DESIGN BRIEF- 3055 Richmond Road

2022-10-06

Proposed 4 Storey Residential Building

COMMENTS and RESPONSES from PRE-CONSULTATION with CITY PLANNERS

DRAWING NAME: FLOOR PLANS

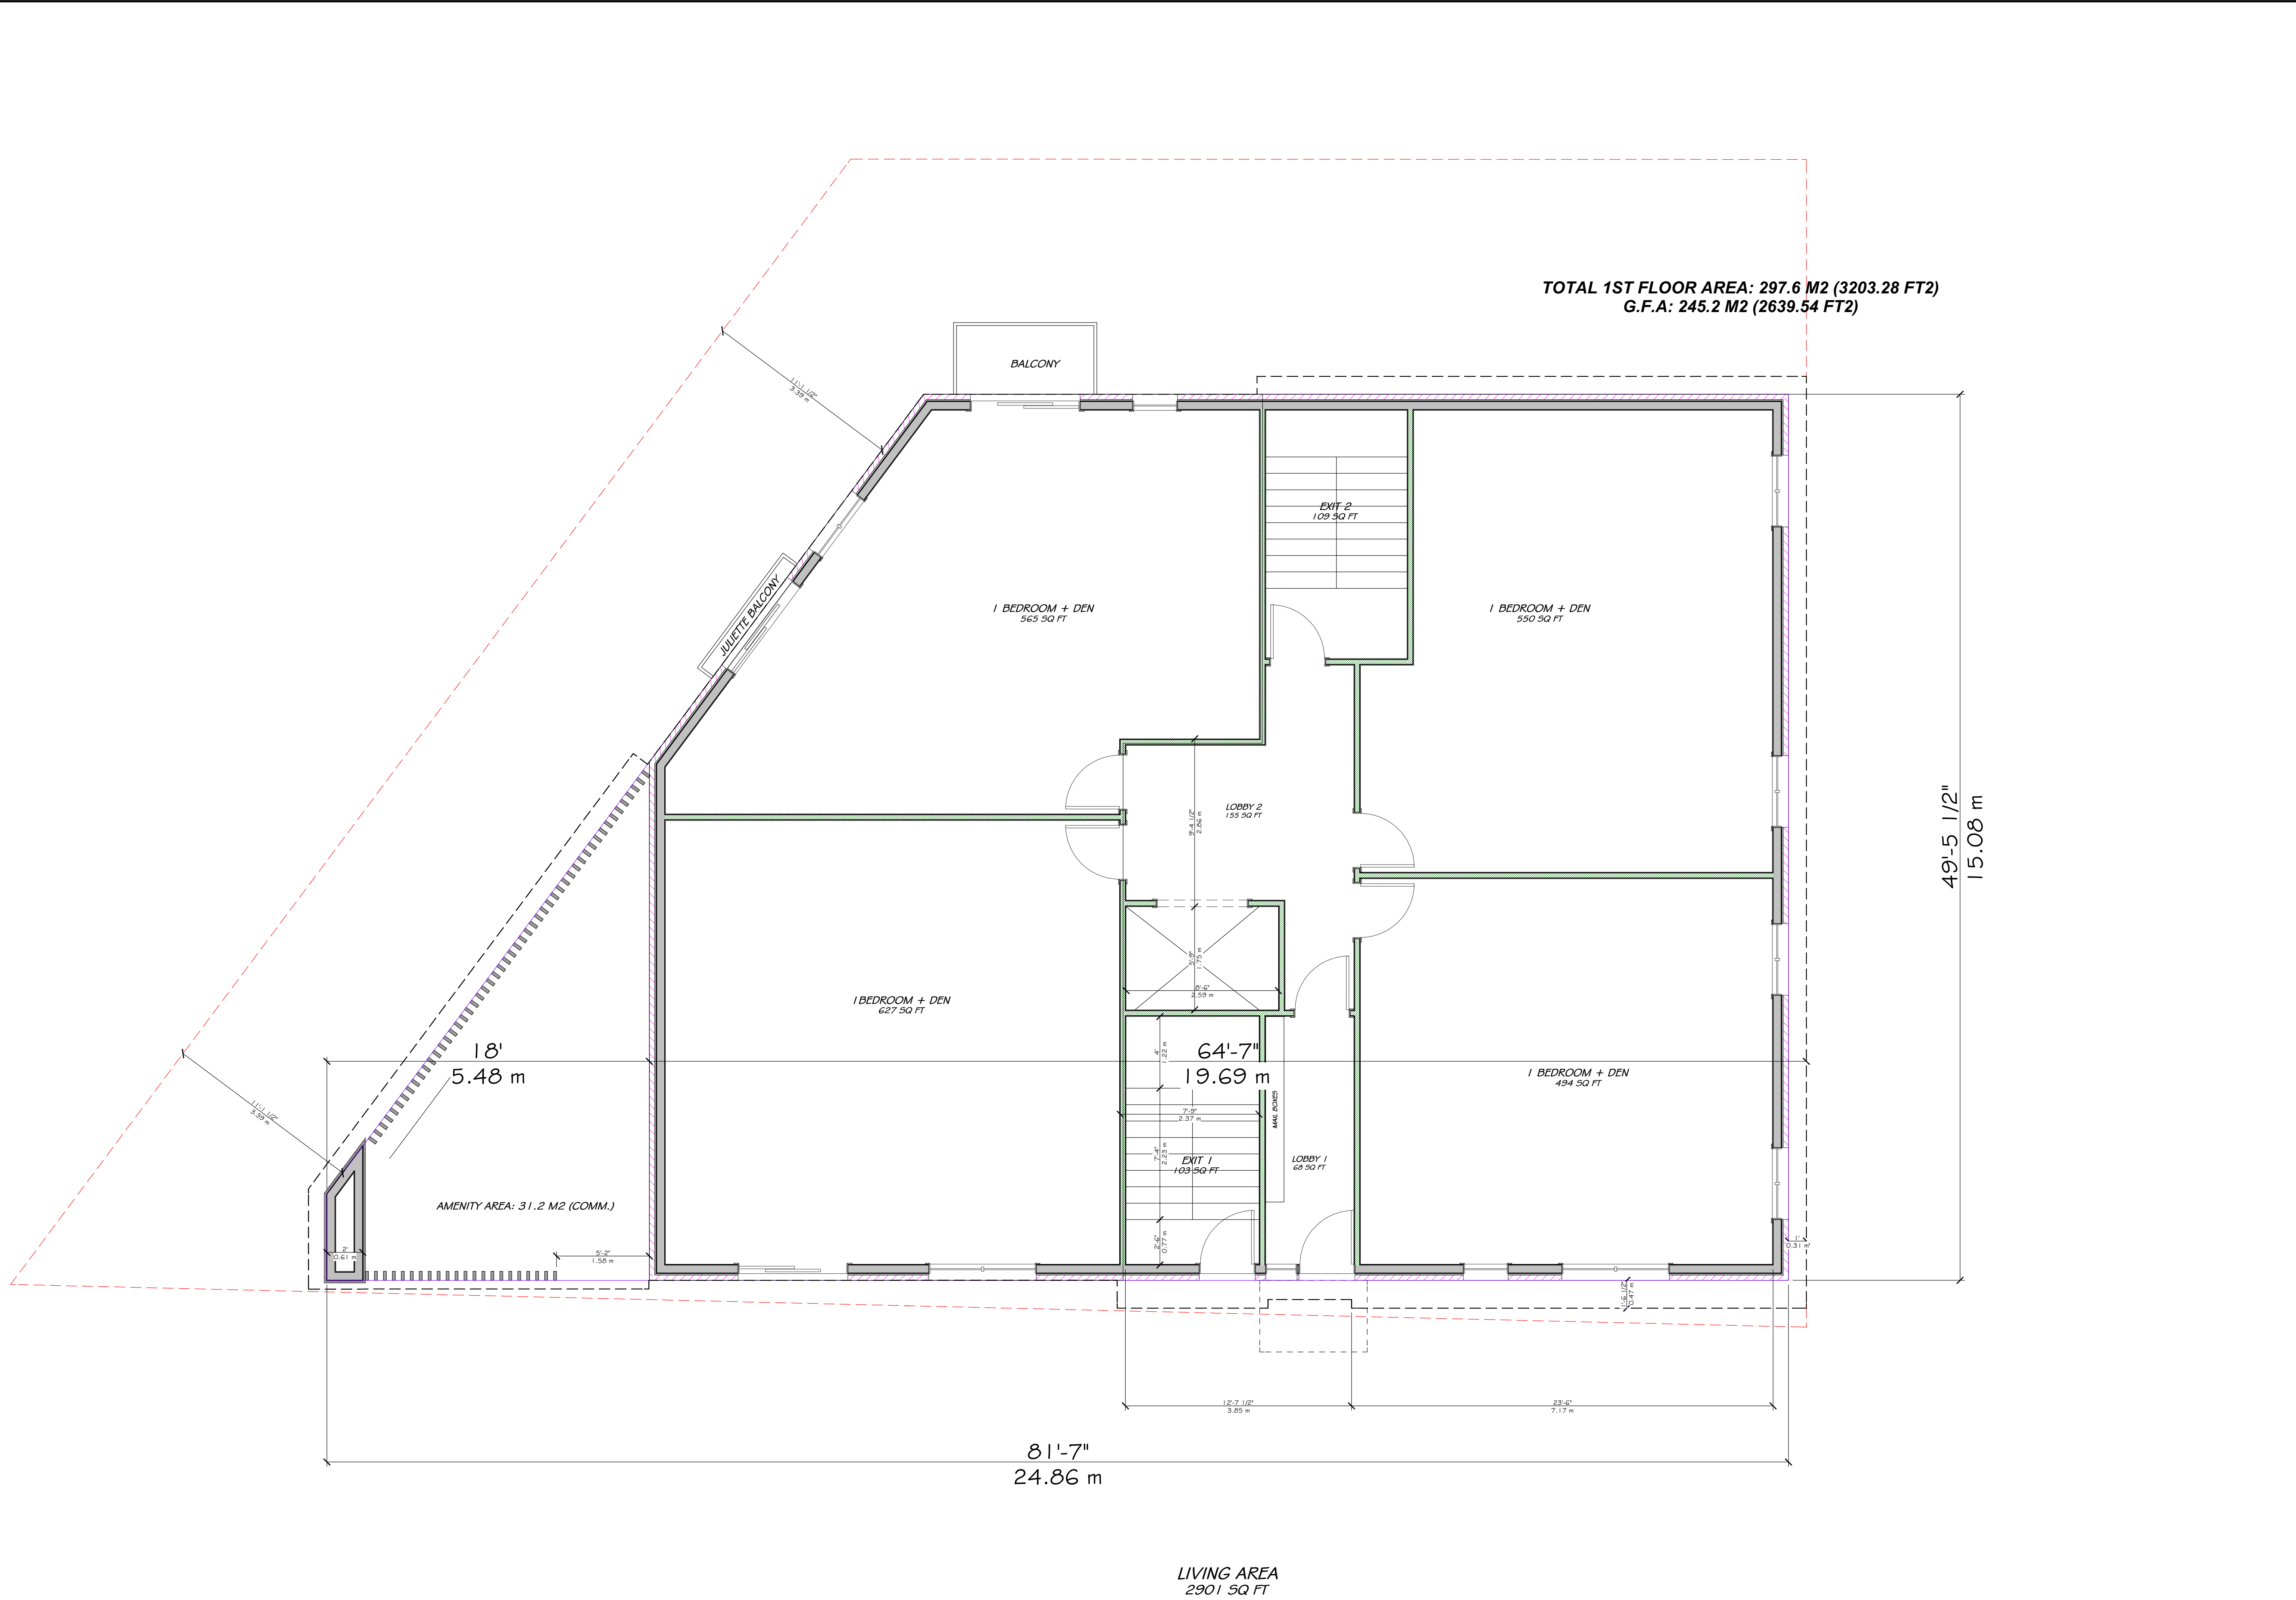
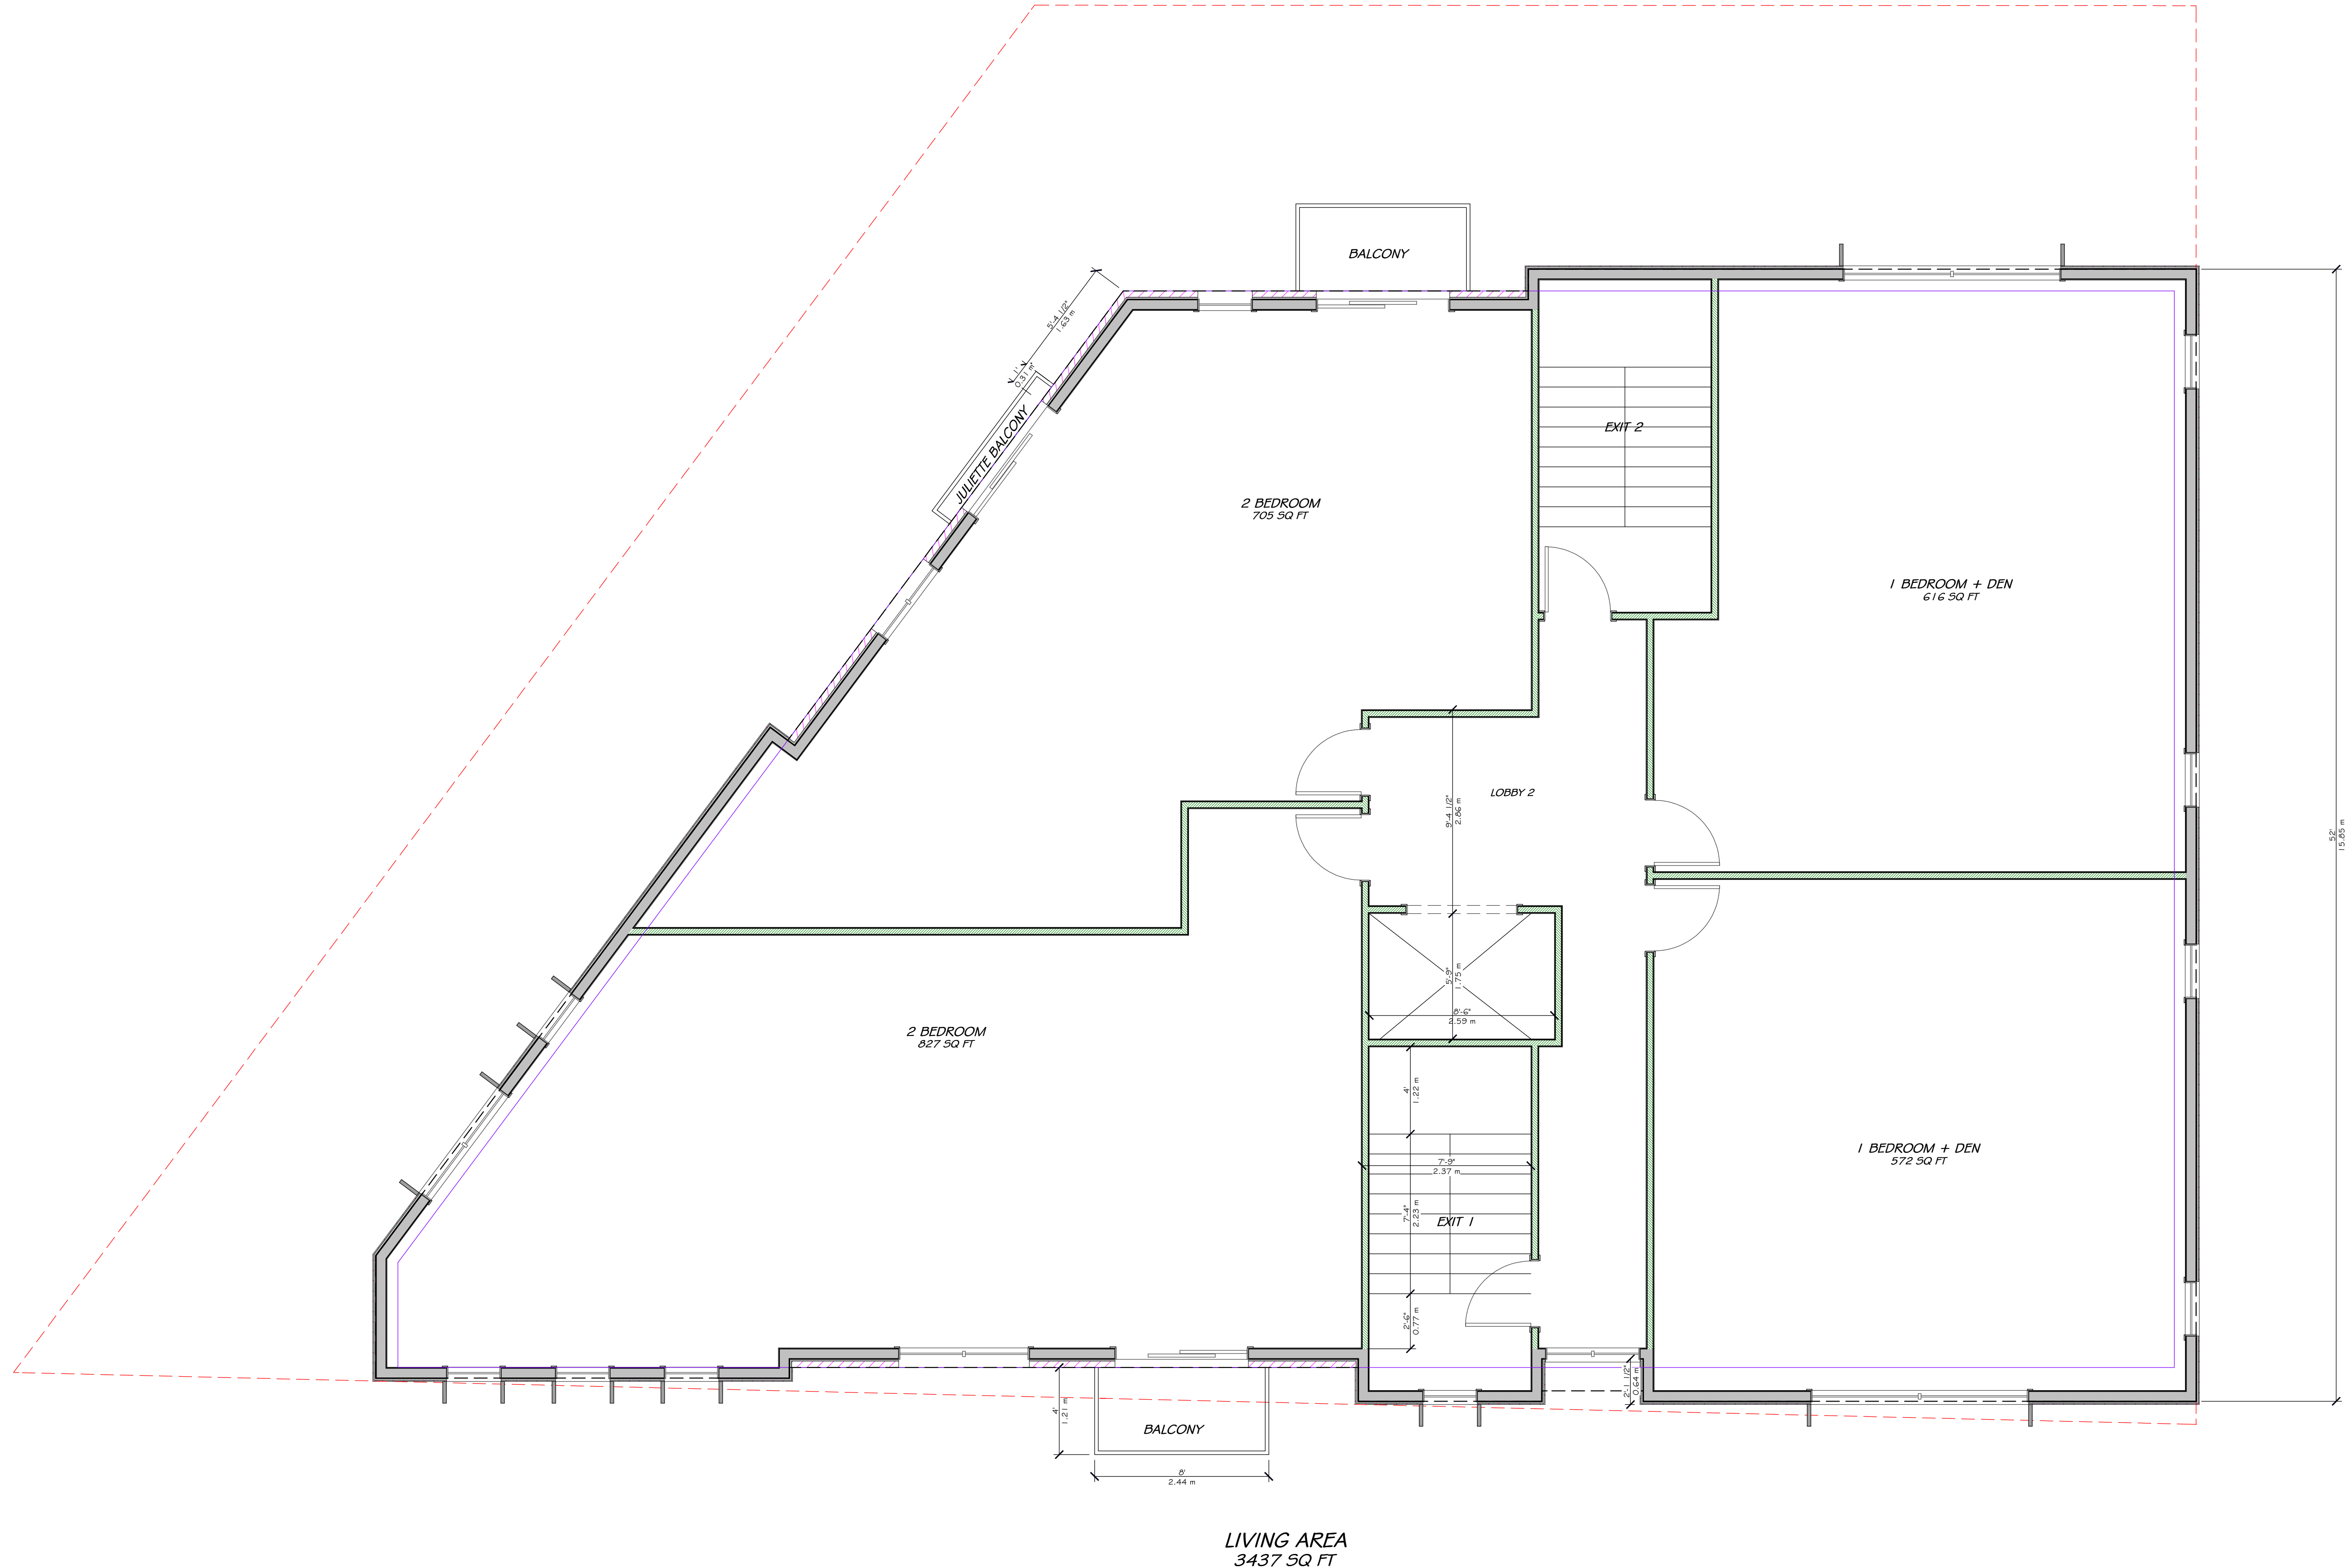
Comment: *Please illustrate how the site size with this level of density can still provide all of the site plan requirements (amenity, parking, bike storage, protected garbage storage, access, etc.).*

Comment: *It is not clear where the full amount of amenity will be located? What will its usability be for the residents? How will it be accessed from the building? Will there be rooftop amenity?*

Comment: *It is recommended that a project of this scale and density provide garbage storage internal to the building.*

Response: In the floor plans included with this brief, are shown the provisions for bicycle parking on the first floor and waste management room on the basement floor with access from the rear parking. As shown in the renderings throughout, vehicle parking is provided in the rear yard and common amenity space is located on the roof.

Response: Common amenity space is provided on the roof and accessible to the tenants via elevator and stair. There are private balconies off the units on the west side of the building.

Response: A garbage room has been provided in the basement off the surface parking area.
